Council Reference: DA04/0016.16 LN22600
Your Reference: DA456-10-2003 MOD 6

**Development Application DA04/0016.16 - amendment to
Development Consent DA04/0016 for mixed residential
commercial/tourist accommodation (DA 456-10-2003) at Lot B
DP 332137; Lot 1 DP 962785, Lot 1 DP 962784 and Lot 2 Sec 1
DP 75827925 No. 25-33 Wharf Street TWEED HEADS**

I refer to your letter dated 25 November 2013 in which you seek Council comment on DA 456-10-2003 MOD 6. Accordingly Council makes the following comments

Figure 8: Preferred ground level plan with new screening and retail tenancy.

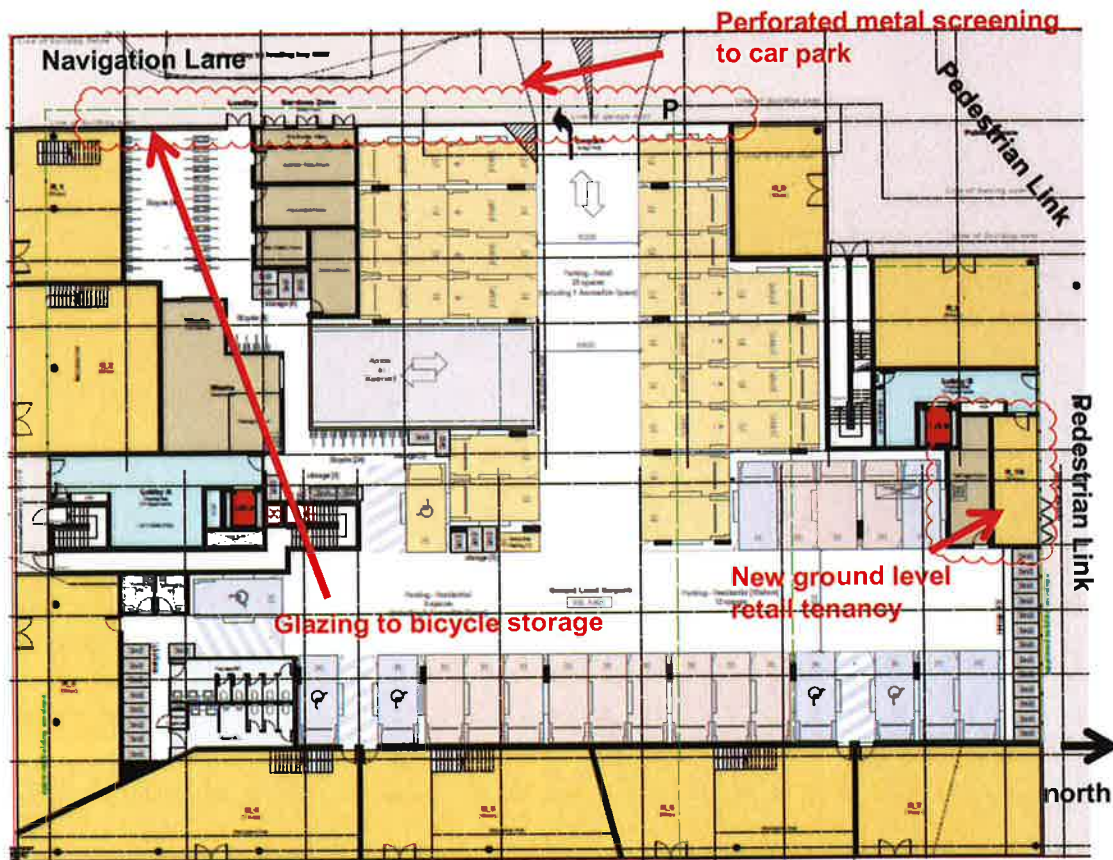
- Council Officers are concerned that the depth of the proposed retail/office spaces is insufficient to enable flexibility for future tenancies;
- Council Officer's are concerned that the allocation of retail and office space prohibits future use of this area for restaurants or cafes due to the inadequate parking on site for future intensifications;

- The ground floor plan does not clearly delineate which of the nine tenancies are for retail and which are for offices and should do so for clarity.
- Council Officer's want to ensure that the external finishes of the building are undertaken at least to the standard as shown on the plans. Stage 1 of Ultima has no colour and appears unfinished (grey rendered concrete only). It is considered crucial that the external finishes for Stage 2 have a variety of materials and colours to improve the streetscape in this prominent location.

In regard to the retail component 21 spaces are provided as required. Tweed DCP-B2 does not differentiate between staff and customer parking in the specified rate, however these spaces must be available for both user groups. The major concern is that 16 of the 21 spaces are in a tandem configuration, rendering them unsuitable for customer car parking and short term staff use.

It is considered that the proposed parking layout has an overuse of tandem spaces for the retail component **and must be reconfigured to meet Council's requirements.**

Access to the retail parking spaces must be made freely available to the public, requiring the deletion of the sliding car park doors. Other areas of the car park are secured from the public, so the external doors are unnecessary.

Figure 15: Indented service bay along Navigation Lane.

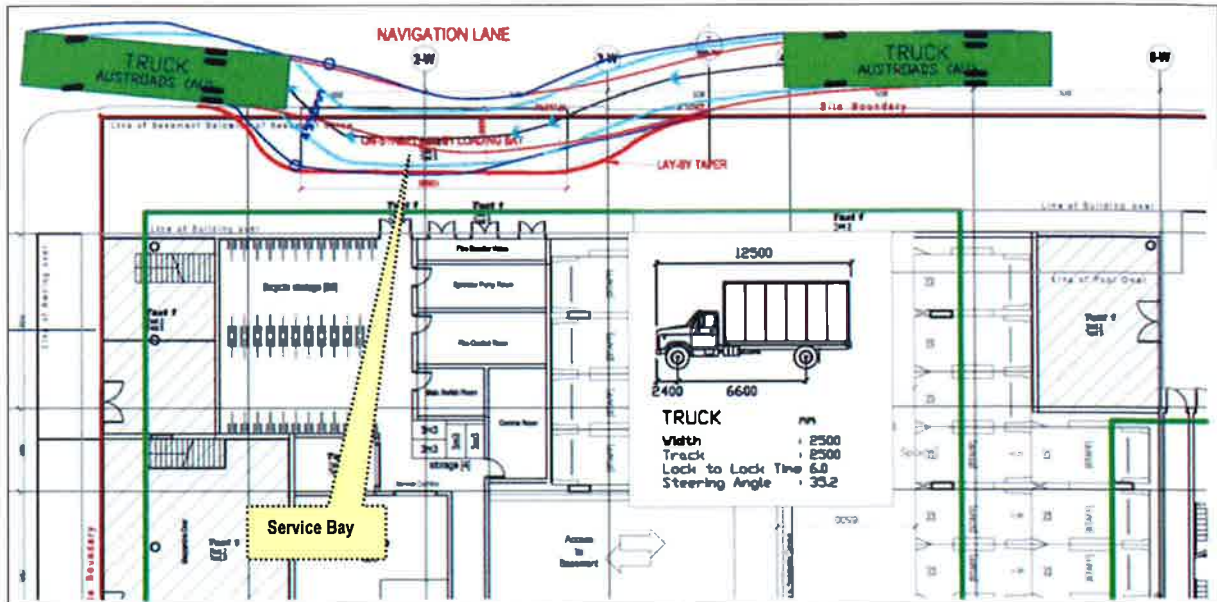
- It is noted service vehicle access is from Navigation Lane. This access requires reversing from Navigation Lane into the service access bay. All service vehicle arrangements should be able to drive forward into the access bay and exit the site in a forward direction. The application states that this type of arrangement was approved in the original development by the Department of Planning and is proposed in the amended development due to the 'constrained nature' of the laneway. This type of arrangement for a service bay is not generally supported. It is noted that this arrangement has been previously approved for the original development.
